# FALCON FIELD

### PRELIMINARY PLAN

#### NORTH EAST 1/4, SECTION 7, TOWNSHIP 13 SOUTH, RANGE 64 WEST

OVERALL SITE MAP

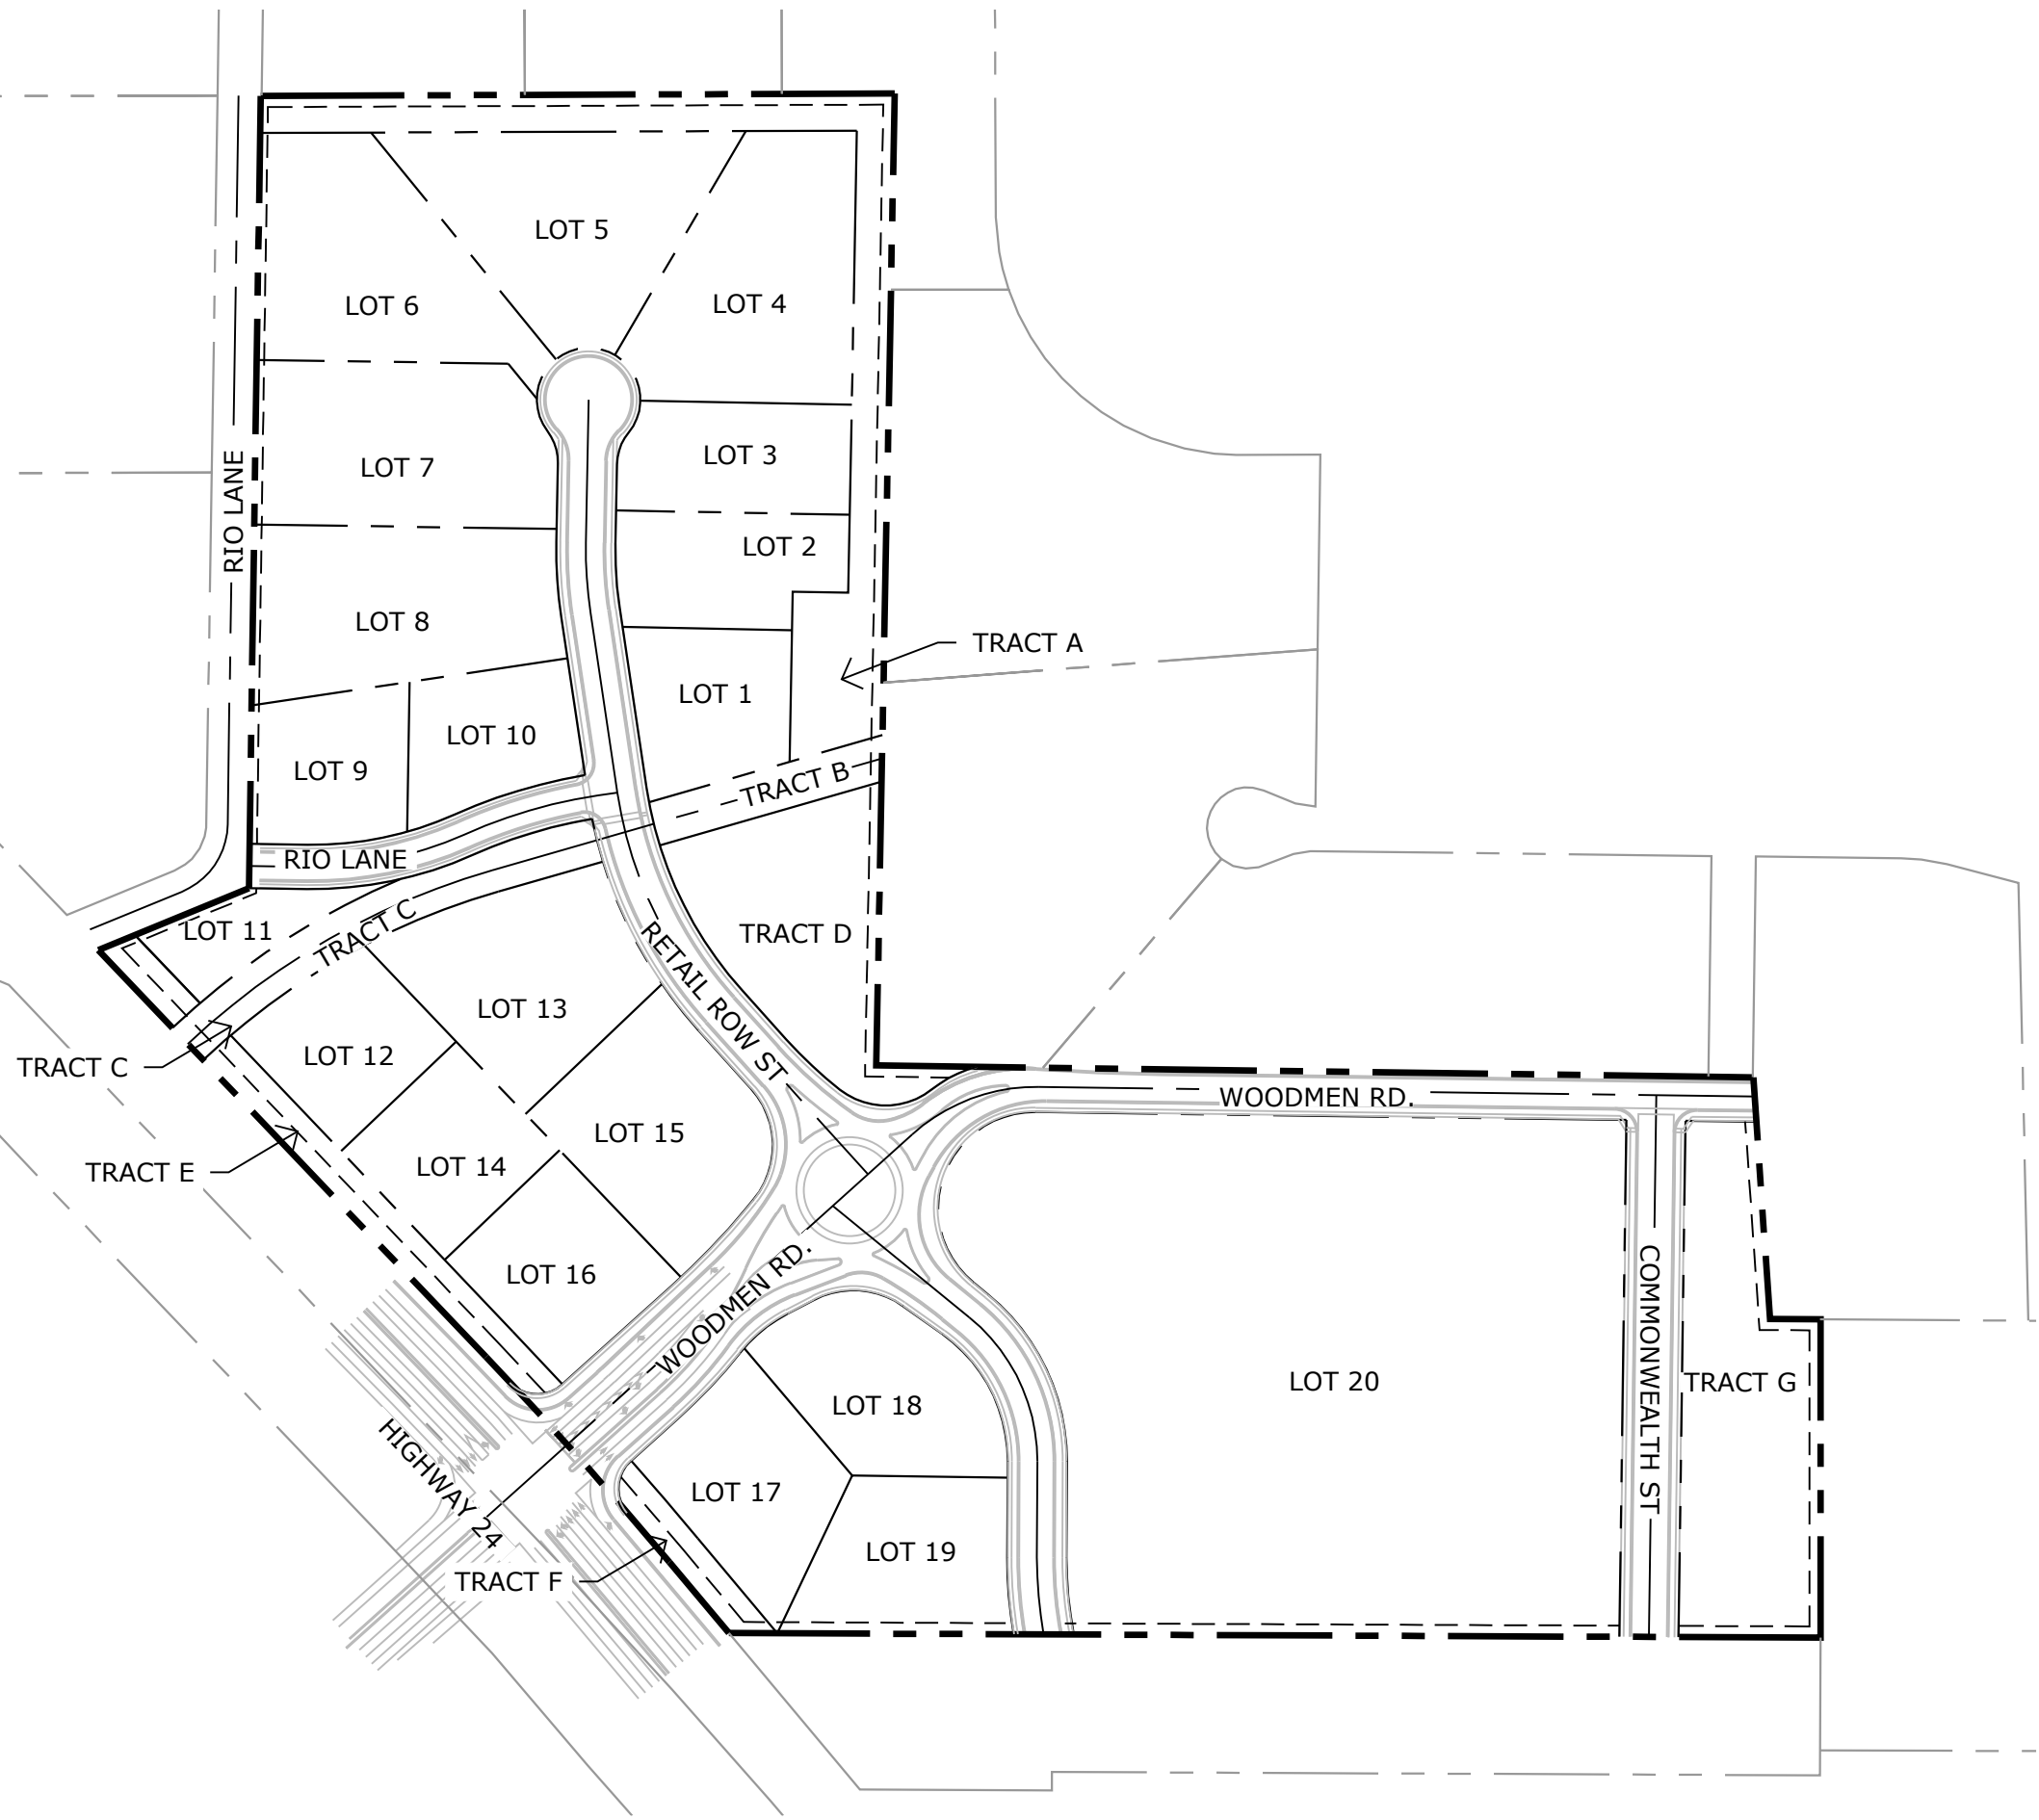
This does not appear to be accounted for on the east side where Woodmen Road extension abuts lots to the east.

A URBAN RESIDENTIAL COLLECTOR ROADWAY STANDARD CROSS SECTION (60' RIGHT-OF-WAY)

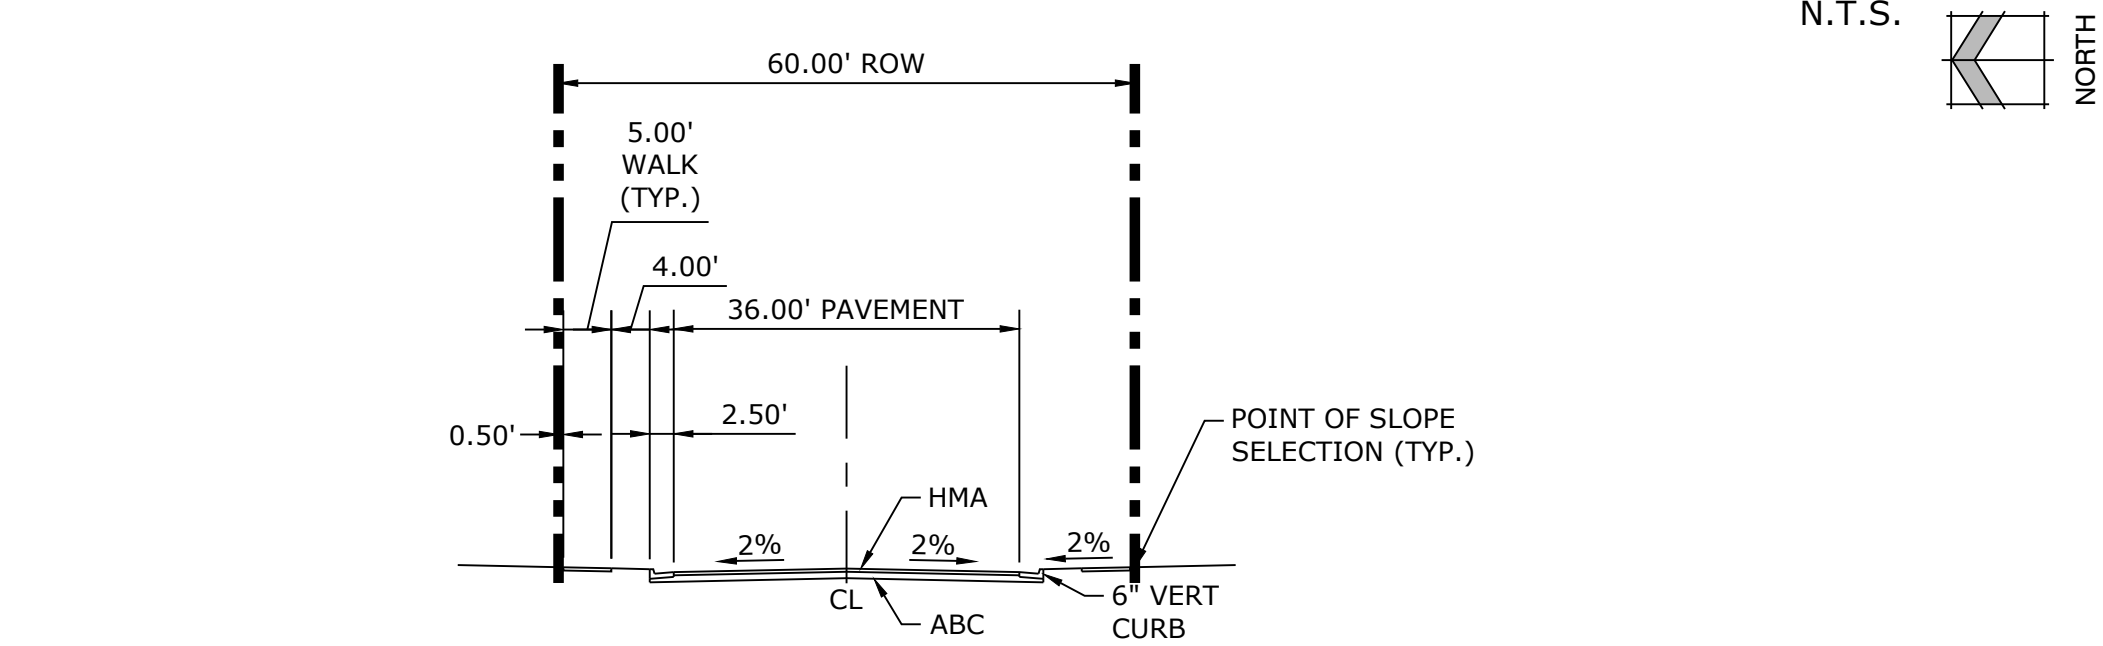
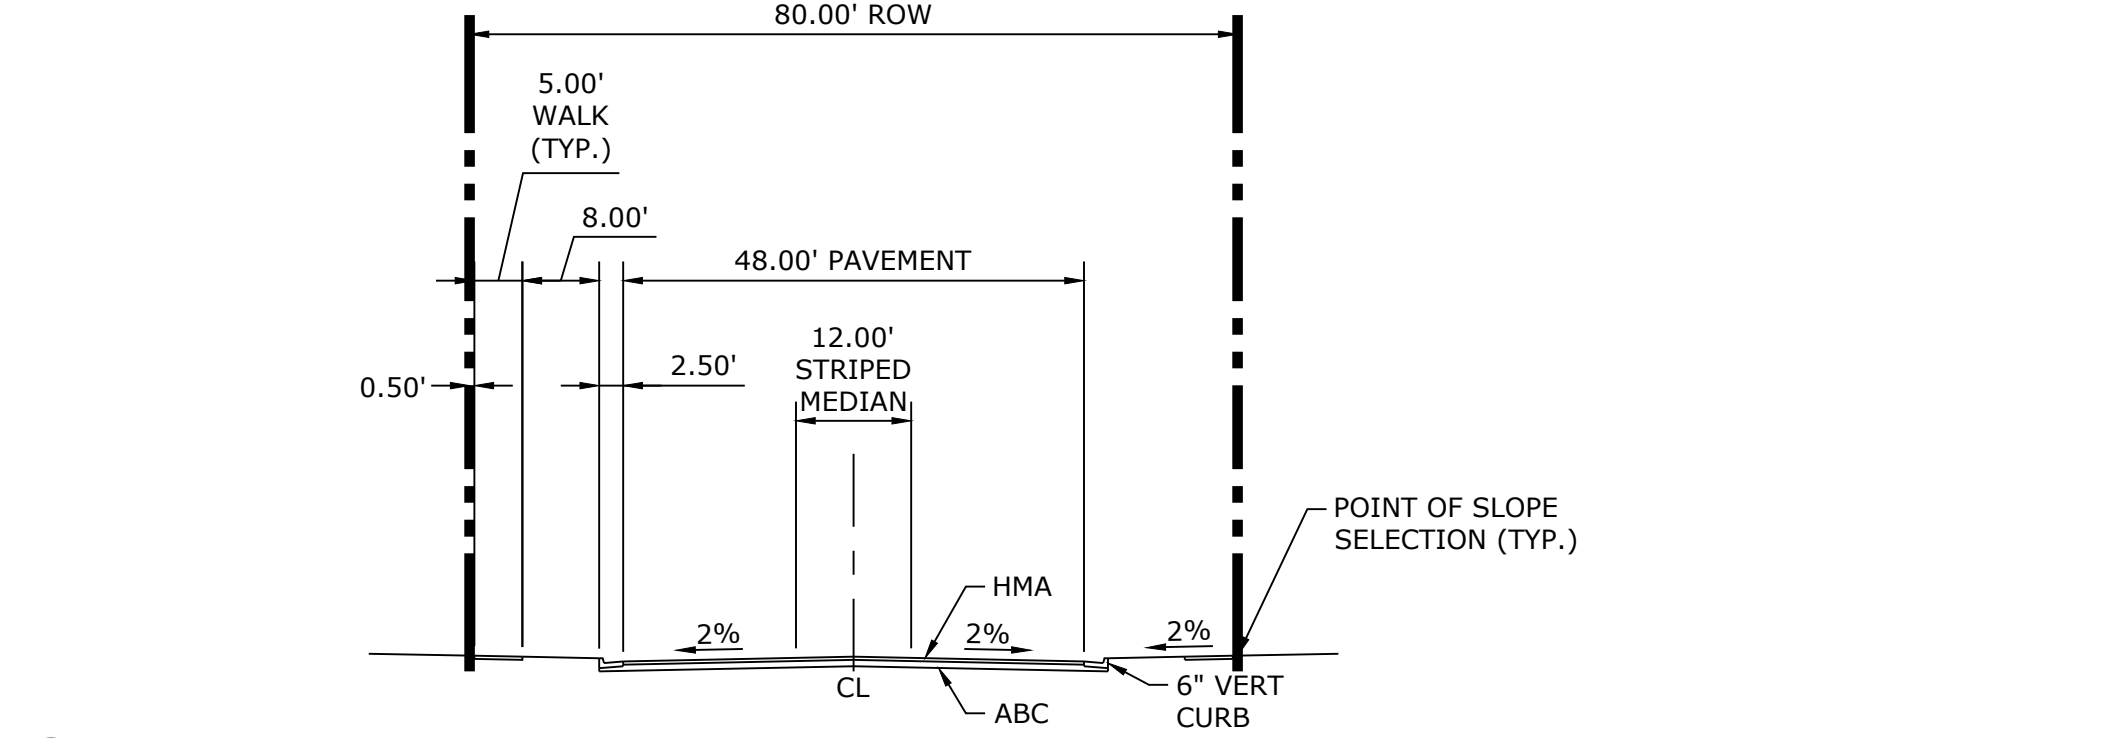
If a screening wall is required along one of the roads please show it on the cross-section.

Where is this cross-section used?
